Subject: Portland Congregation of Jehovah's Witnesses; Kingdom Hall Remodel

This letter is written in response to your recent review comments of March 23, 2012 regarding the subject project. Specifically it addresses the two comments regarding the (1) subsoil conditions and (2) the point load of the LVL beam.

2 ELEVATION OF LVL HEADER
RA4.2 SCALE: 1/4"=1'-0"

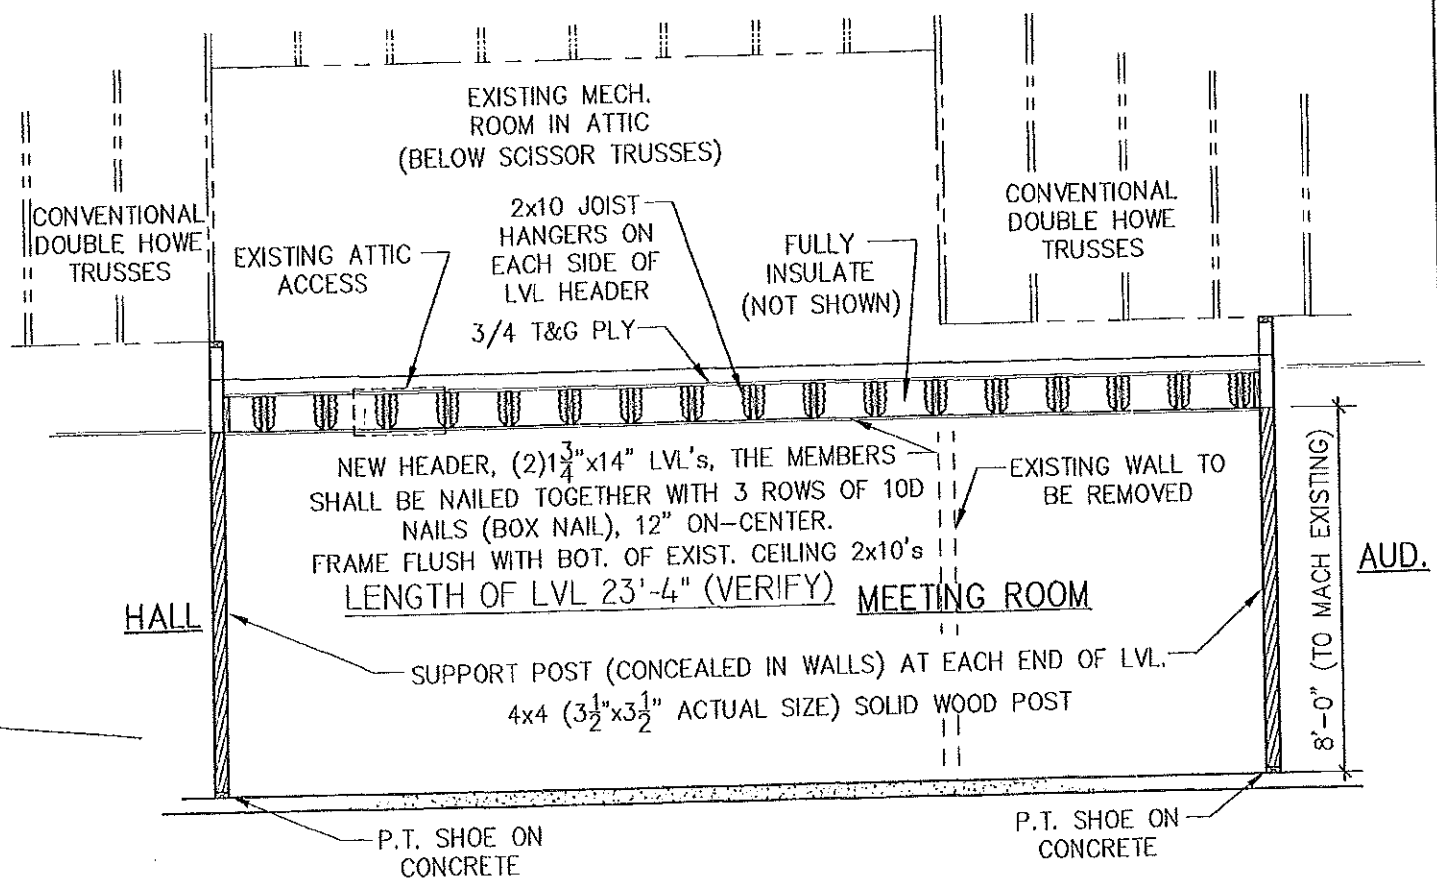
2. The capacity of the proposed plate and existing slab were evaluated with regard to the loading from the LVL in the meeting room and the plans reflect what is required. The slab does not require an additional footing and the plate has capacity for the anticipated loading.

2 FOUNDATION SECTION (NORTH-SOUTH)
RF1.1 SCALE: 1"=1'-0"

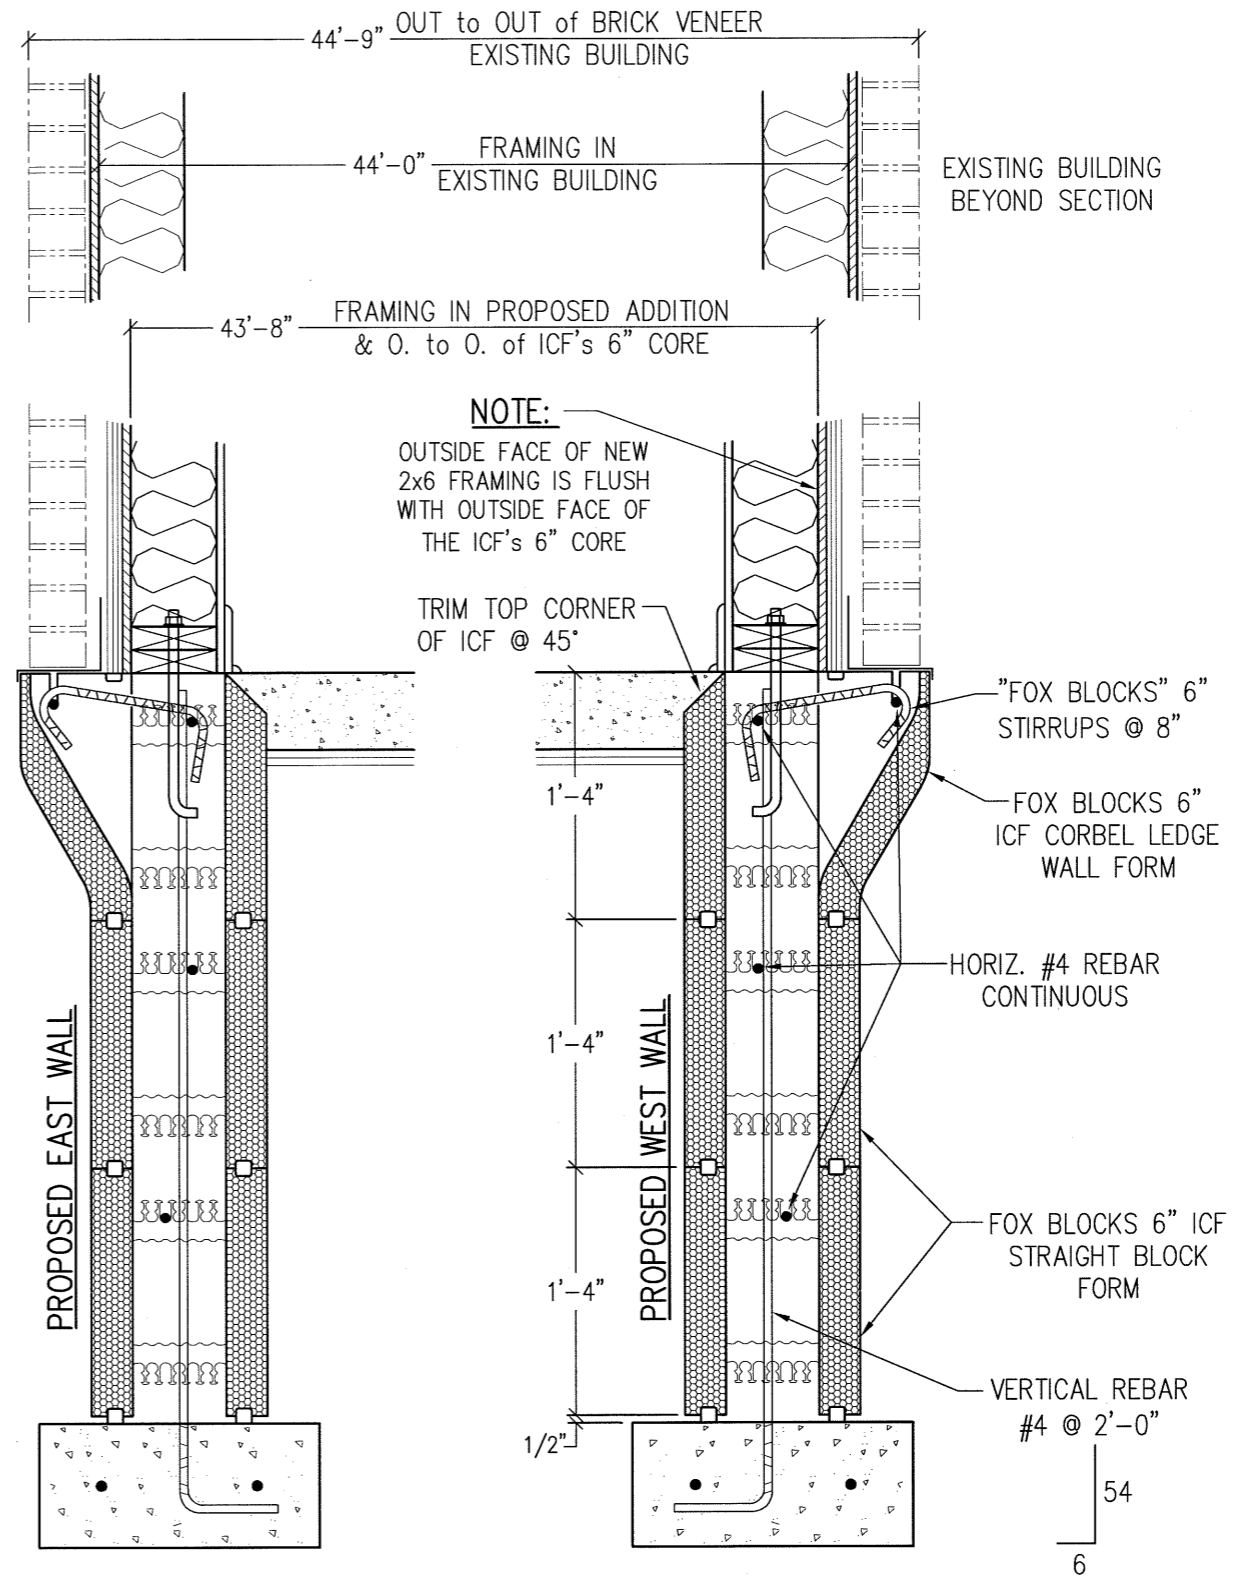
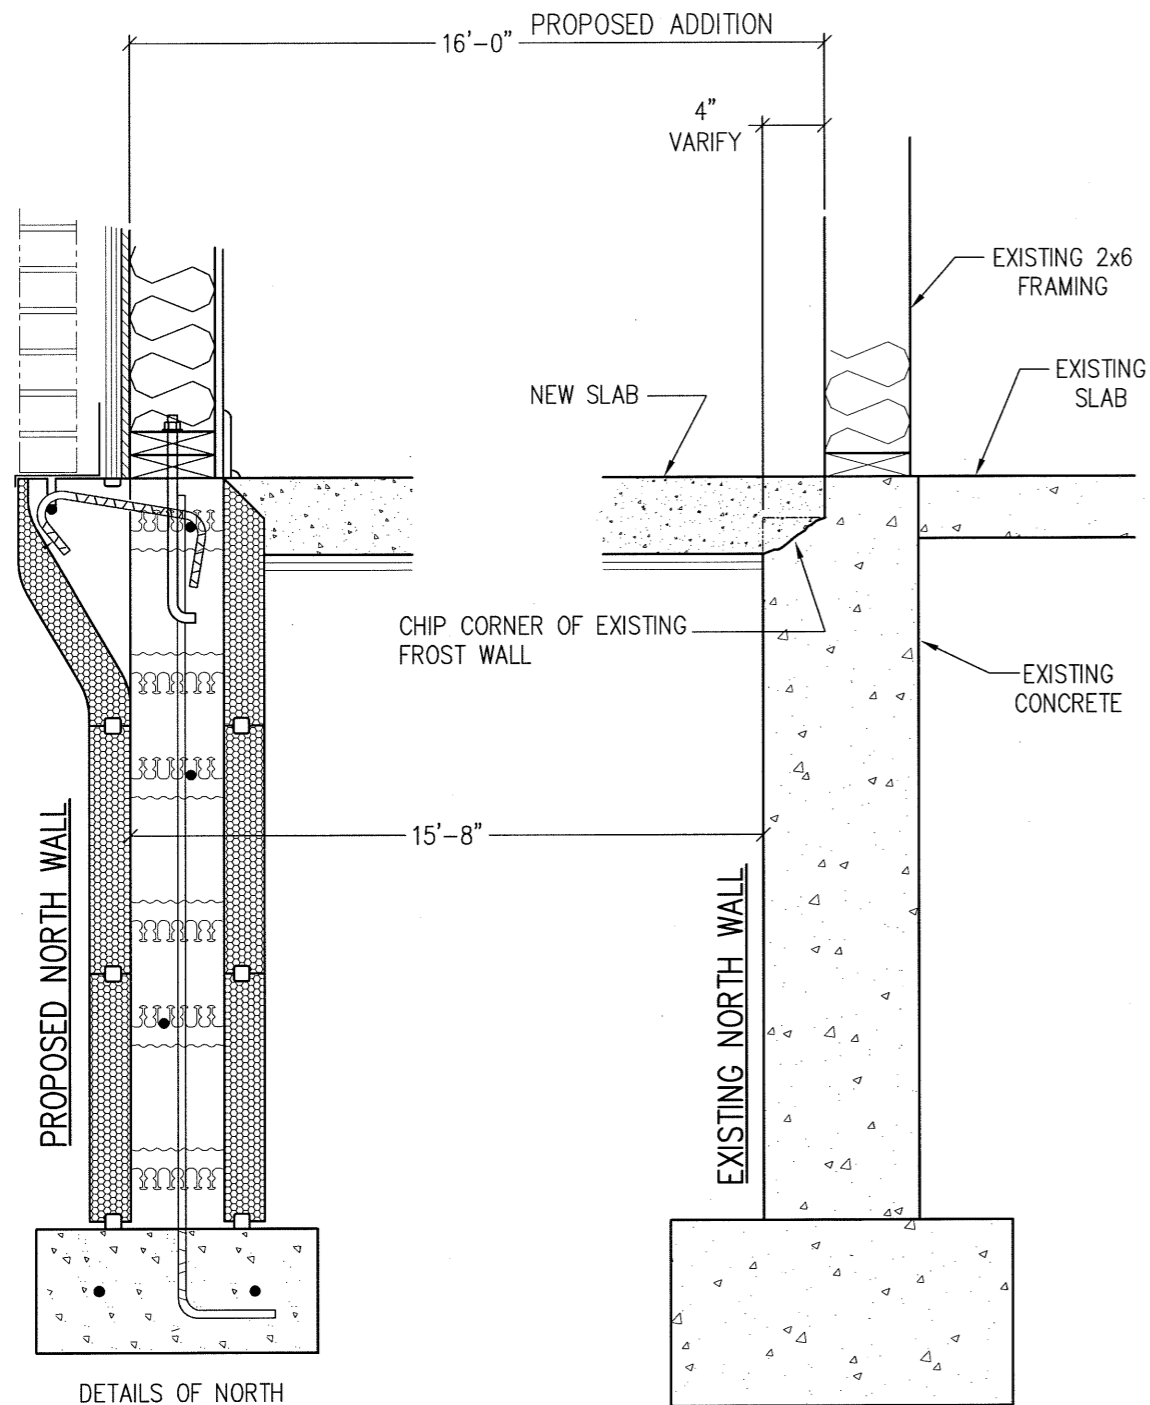
1. A geotechnical report was not obtained as the addition to the building is directly adjacent to the existing building. For design purposes, we felt that the exemption allowed under IBC 1803.2 would apply since the existing building has the same building section and foundation type as the proposed addition and has performed adequately for quite a number of years. The footing is therefore designed according to the presumptive load bearing values of Table 1806.2 assuming clay, sandy clay, silty clay, silt and sandy silt (1,500 psf). We also anticipate visiting the site during the foundation excavation to verify subgrade soil type and bearing capacity. If the subgrade is found to have a lower bearing capacity, the footing width will be increased to accommodate a weaker soil. We can provide the City a letter of findings and modifications (if required) subsequent to this event should you desire.
